**WELWYN HATFIELD COUNCIL – DEVELOPMENT CONTROL**  
**DELEGATED REPORT**

<b>APPLICATION No:</b>	<b>S6/2010/0691/LU</b>
------------------------	------------------------

The proposal is to raise the height of the roof above the existing side extension comprising of the reading room and two en suite bathrooms by a further 1.14 metres to be in line with height of the roof of the original dwellinghouse.

Title
 PROPOSED CROSS SECTION A-A

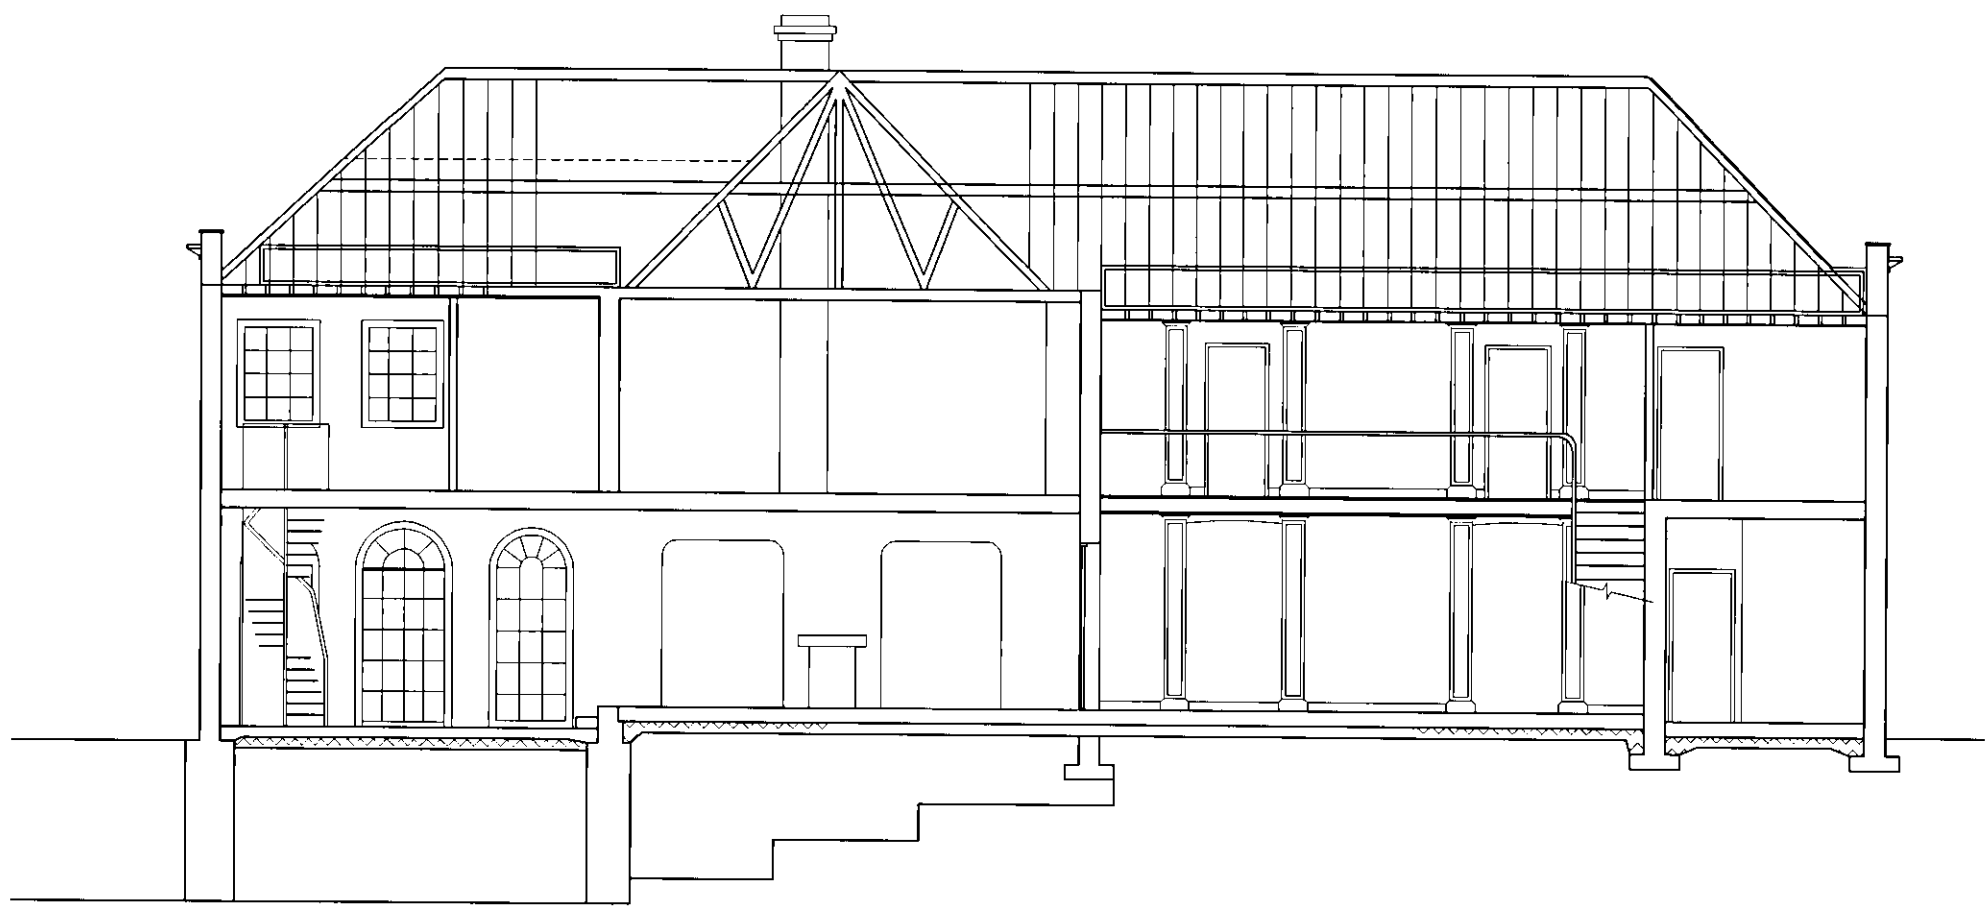
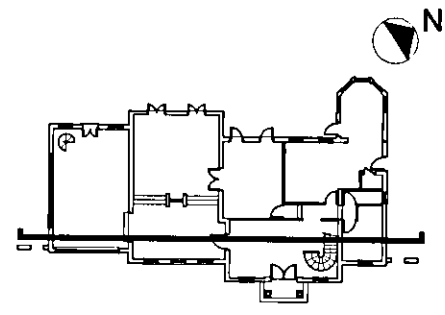
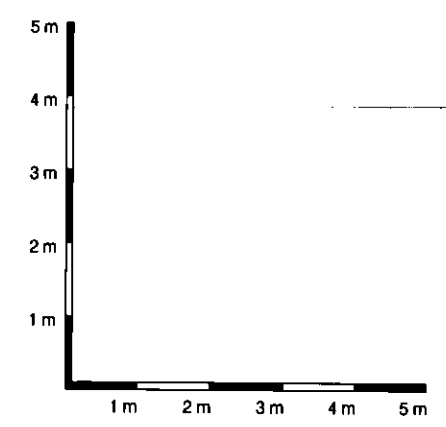
*Existing extension to roofspace: width 5.08m x depth 6.65m x height 0.95m = 32.1m<sup>3</sup>  
Proposed extension to roofspace: width 5.08m x depth 4.6m x height 1.14m = 26.5m<sup>3</sup>*

*Total additional roofspace to original dwellinghouse: 32.1m<sup>3</sup> + 26.5m<sup>3</sup> = 58.6m<sup>3</sup>*

*The proposal therefore fails to comply with Class B (c) (ii) by virtue of the additional roof space exceeding 50 cubic metres.*

Title
PROPOSED ELEVATIONS

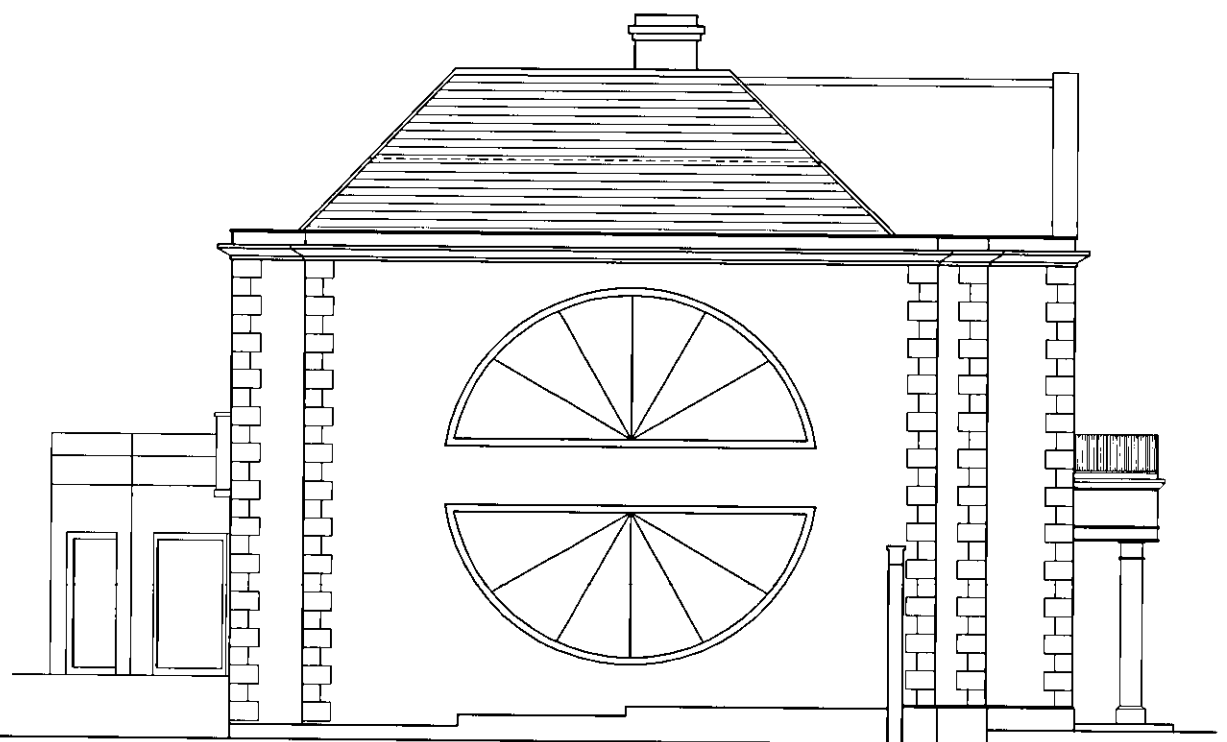
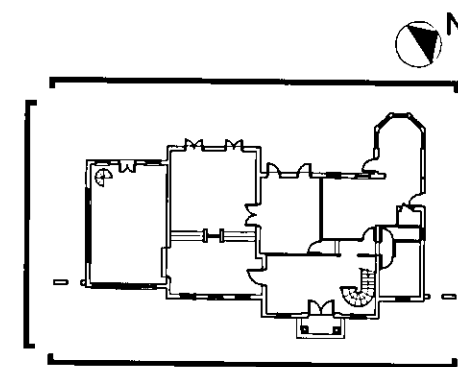
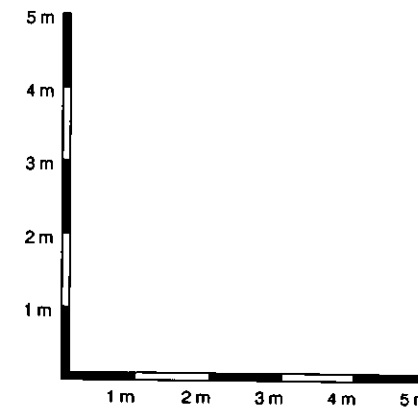
*As a result of the works, the dwellinghouse would not exceed the height of the highest part of the existing roof.*

*The edge of the enlargement closest to the eaves of the original roof would not be less than 20 centimetres from the eaves of the original roof.*

*No windows are proposed.*
